Our Ref: FG/94/17/HH
Your Ref:

Town & Country Planning Act 1990 (as amended)
Town & country Planning (Development Management Procedure) (England) Order 2015
Application for Planning Permission for Works or Extension to a Dwelling

Development Conservatory to rear
Location 2 Birch Place Ferring Lane Ferring

Drawing Title:	Site Plans	
----------------	------------	--

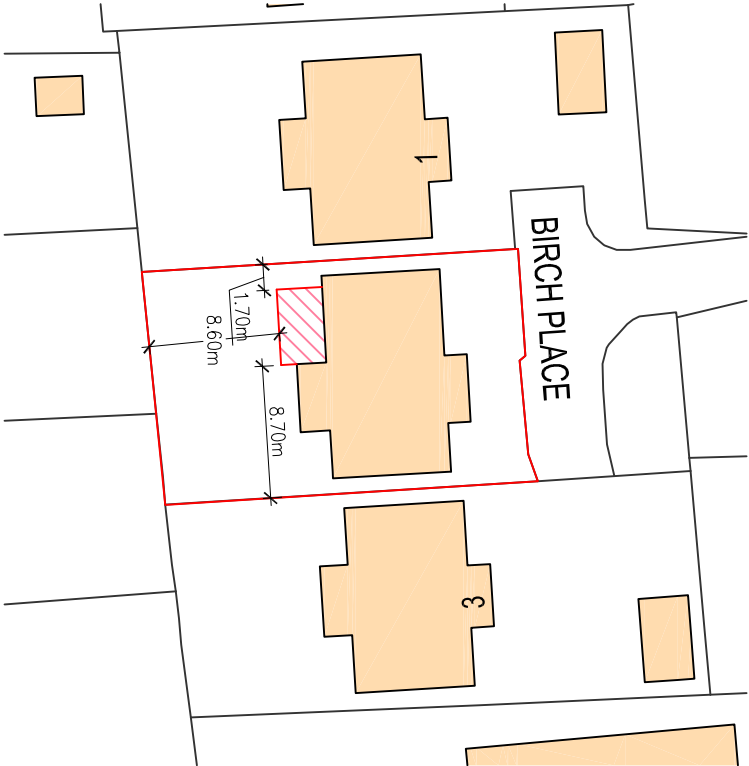
Block Plan Amend

Please submit 1 electronic or 3 paper copies of a block/site plan at a scale of 1:500 or 1:200. Further details of what must be included on the plan can be found in the National Validation Requirements. Please provide measurements from the proposal to the site boundaries.

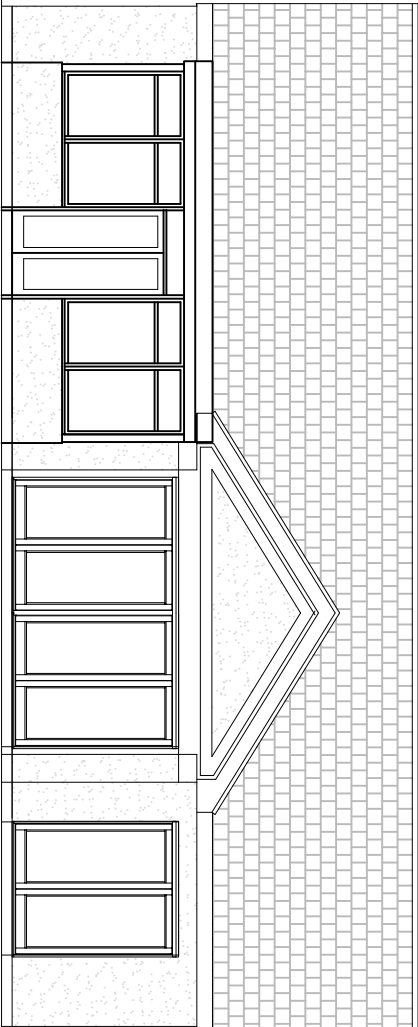
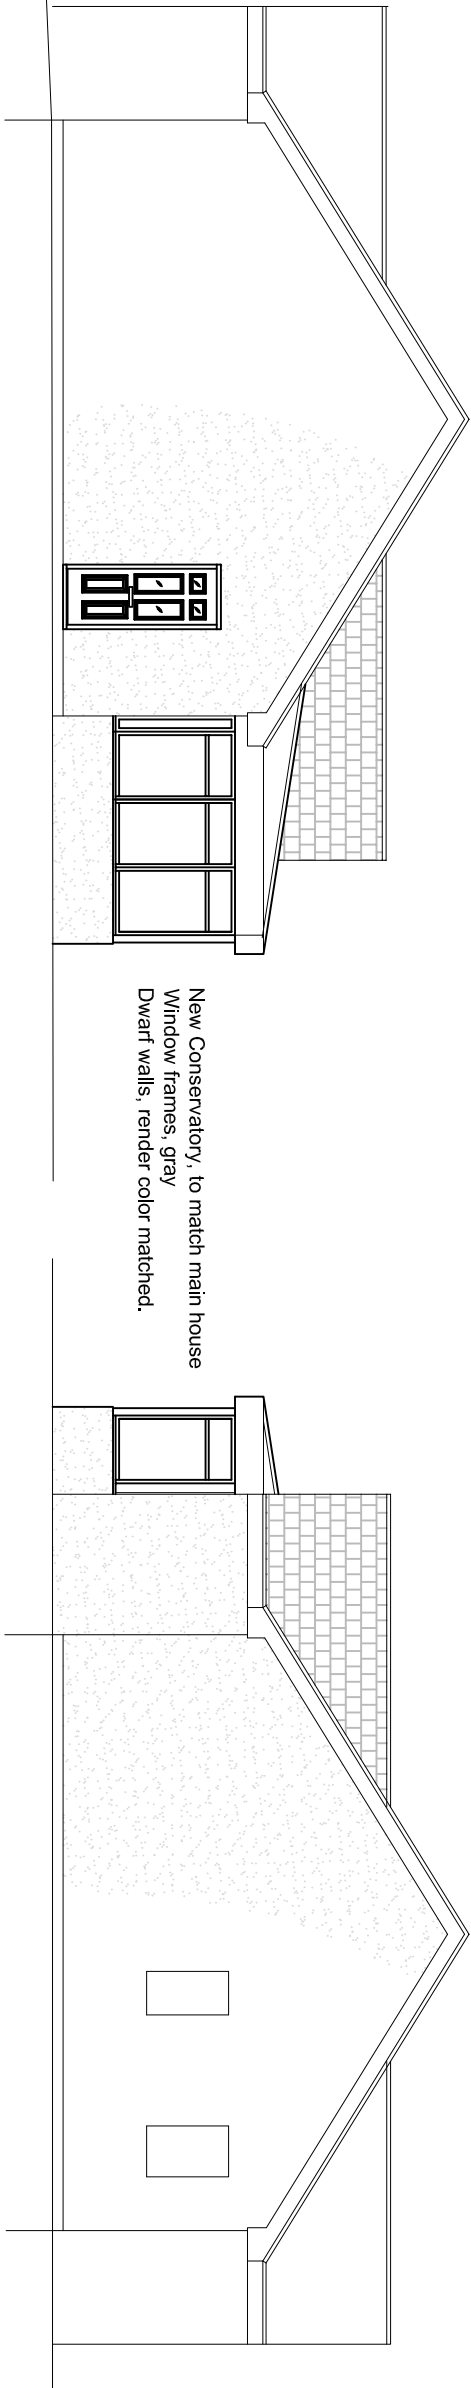
The proposed east and west elevations have been labelled incorrectly. Please amend accordingly.
